APPLICATION FOR THE 'REMOVAL OR VARIATION OF A CONDITION FOLLOWING GRANT OF PLANNING PERMISSION' (SHDC REFERENCE: H18-1034-23) FOR THE "INSTALLATION OF A SOLAR FARM AND BATTERY STORAGE FACILITY WITH ASSOCIATED INFRASTRUCTURE - H18-0741-21 - APPROVED ON APPEAL. MODIFICATION OF CONDITION 3 TO ALLOW THE SOLAR FARM AND BATTERY STORAGE FACILITY TO OPERATE FOR A FURTHER 5 YEARS TO 40 YEARS" AT GUNTHORPE ROAD SOLAR FARM, LAND SOUTH OF GUNTHORPE ROAD, WALPOLE MARSH, WISBECH NEAR PE14 7JH. APPLICATION TO AMEND APPROVED PLANS.

Enso Energy is instructed by Enso Green Holdings R Limited ("the Applicant") to submit a planning application under the terms of Section 73 of the Town and Country Planning Act 1990 (as amended), seeking to amend approved plans, at land south of Gunthorpe Road, Walpole Marsh, Wisbech, near PE14 7JH ("the Site").

DRWG No: WP2-01-P03	Rev: -	Sht no: -
Drawn by : JS	Checked by: OH	
Scale: 1:50 @ A3	Date: 10/05/2024

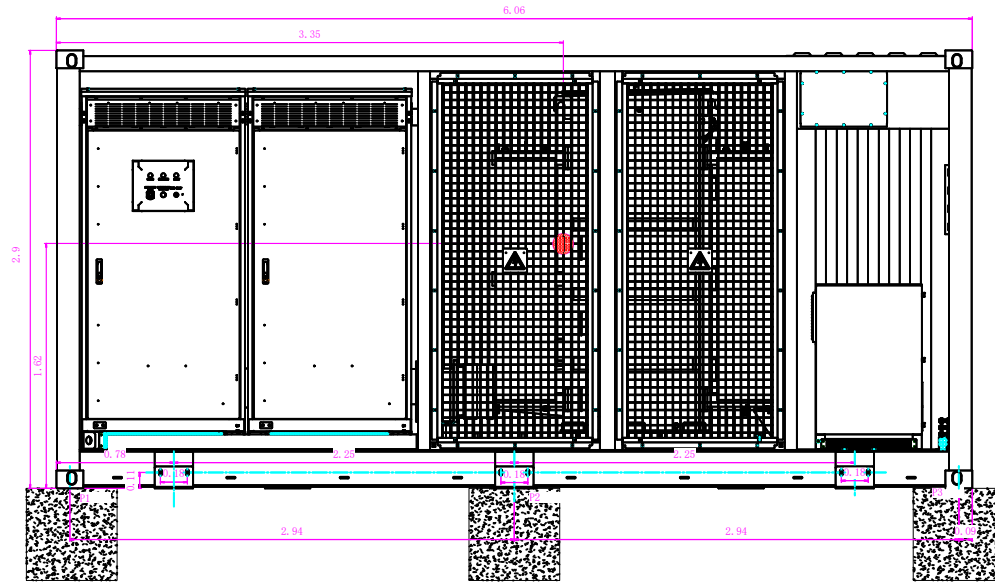
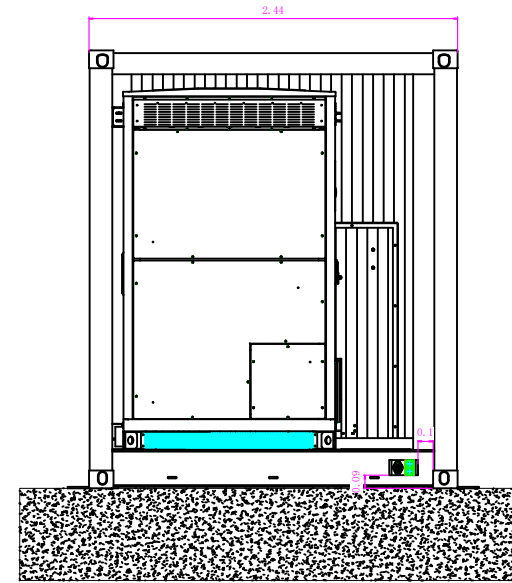
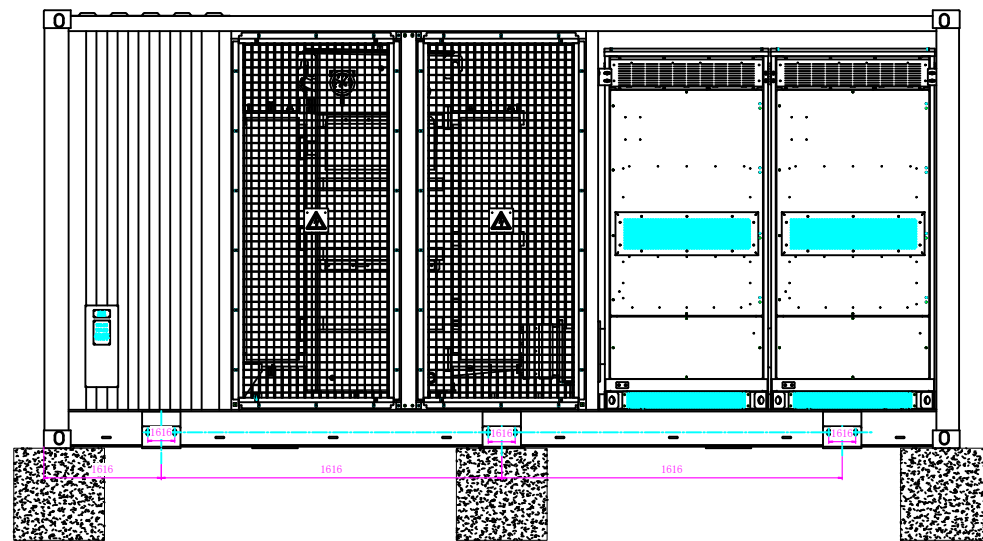
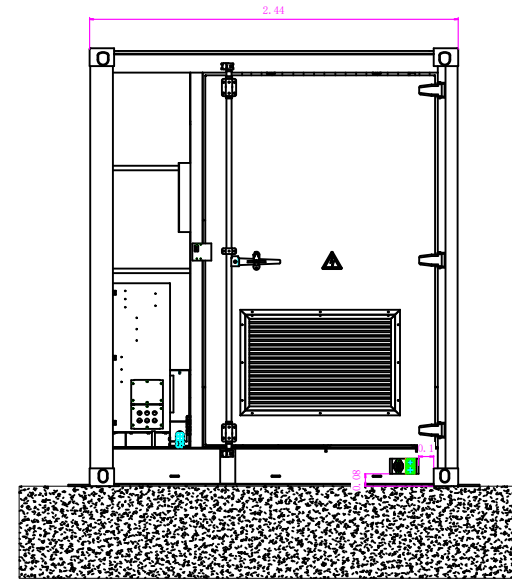
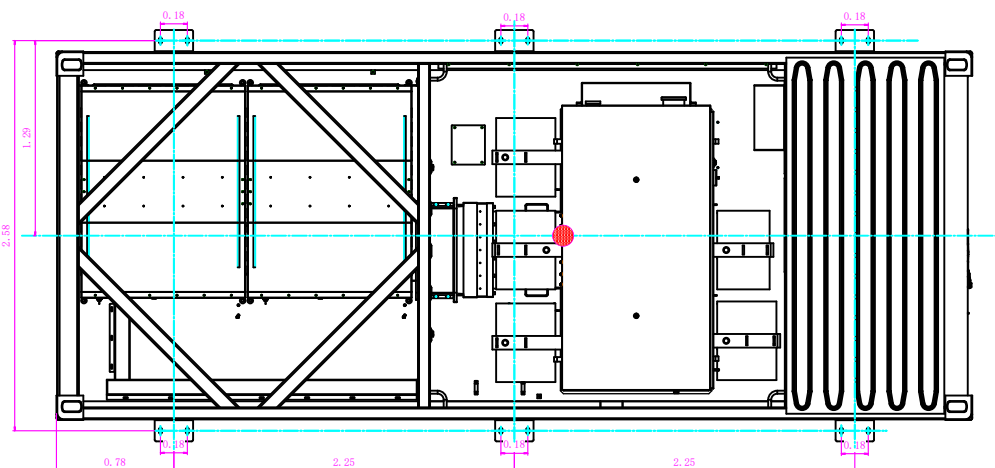
- Amendments to proposed Battery Energy Storage System (BESS) layout, arrangement and design to reflect technology advances since the application was originally submitted in July 2021. A total of 24 battery containers had previously been approved which is proposed to be amended to form 20 'grouped' battery units with increased spacing between groups and external containerised BESS inverters/transformer units on a larger BESS compound. Overall increase in number of total battery units. Elevations of the substation and control room are unchanged (Drawings GR8.0 Rev 01 and GR9.0 Rev 01). New drawings provided for the BESS container elevations (Drawing WP2-01-P04 replacing Drawing GR12.0 Rev 01) and BESS inverters/transformer units (Drawing WP2-01-P03); and

DRWG No: WP2-01-P05	Rev: -	Sht no: -
Drawn by : JS	Checked by: OH	
Scale: 1:200 @ A3	Date: 10/05/2024

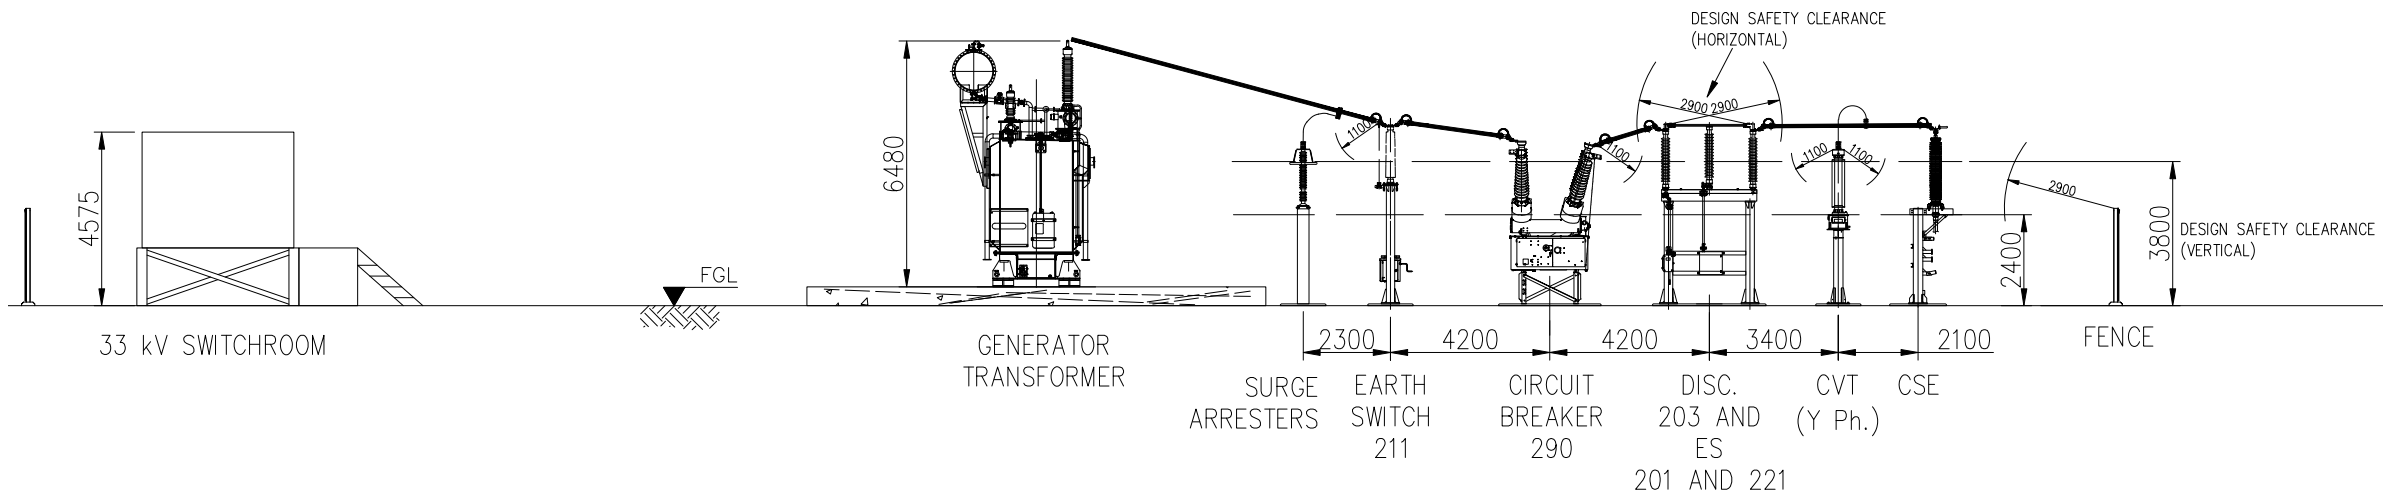
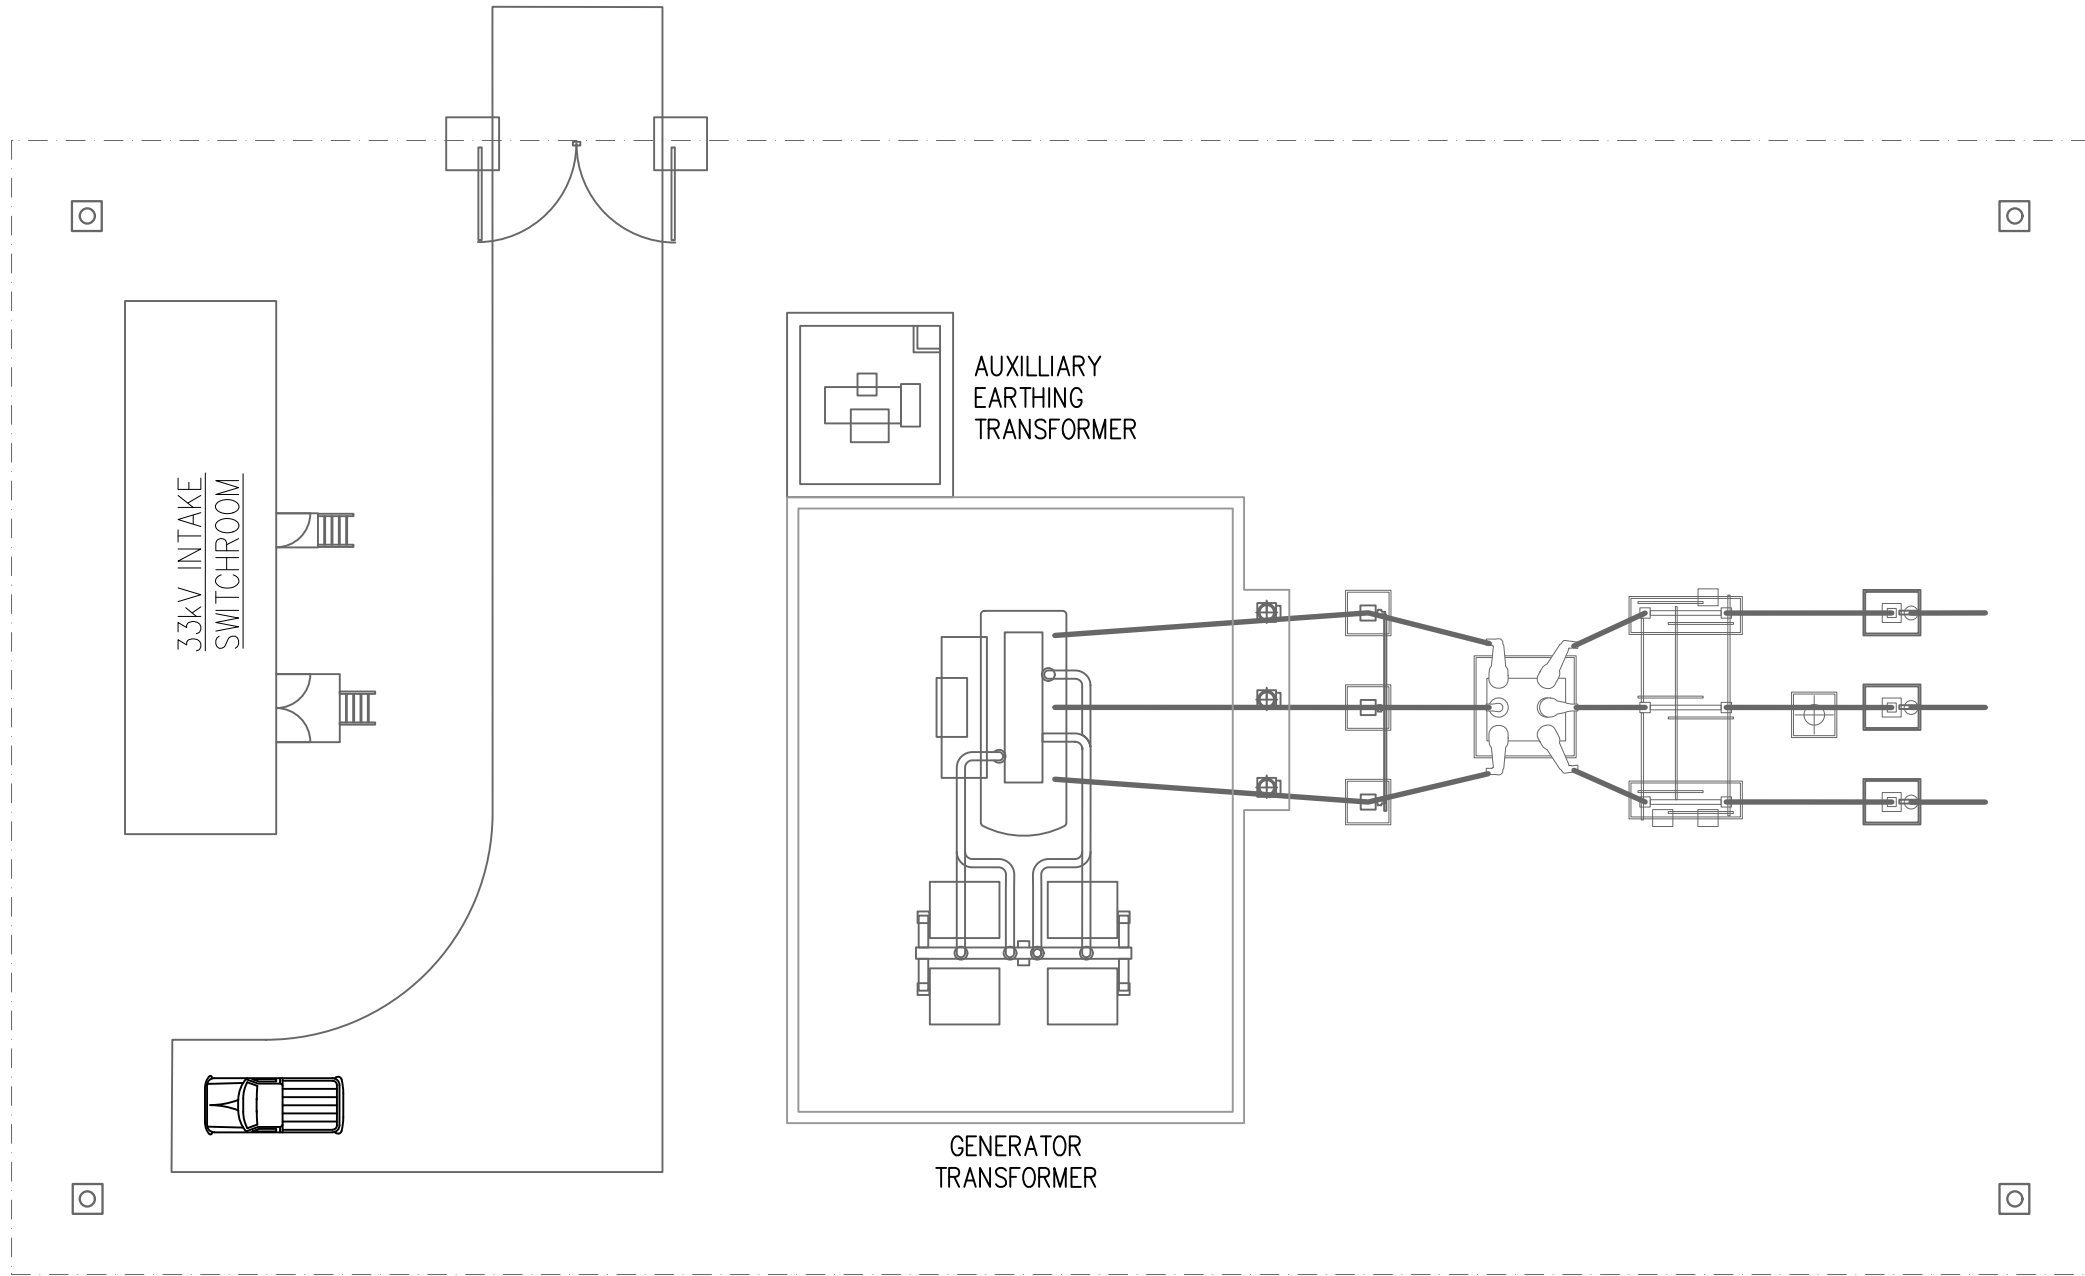
- Changes to layout and design of the on-site Substation are required following final technical confirmation of the connection to the National Grid Walpole Substation previously approved to form the necessary arrangement for a 132 kV connection, together with the removal of the previously approved Auxiliary Transformer (Drawing GR10.0 Rev 01). New drawing provided to detail the 132 kV substation (Drawings WP2-01-P05).
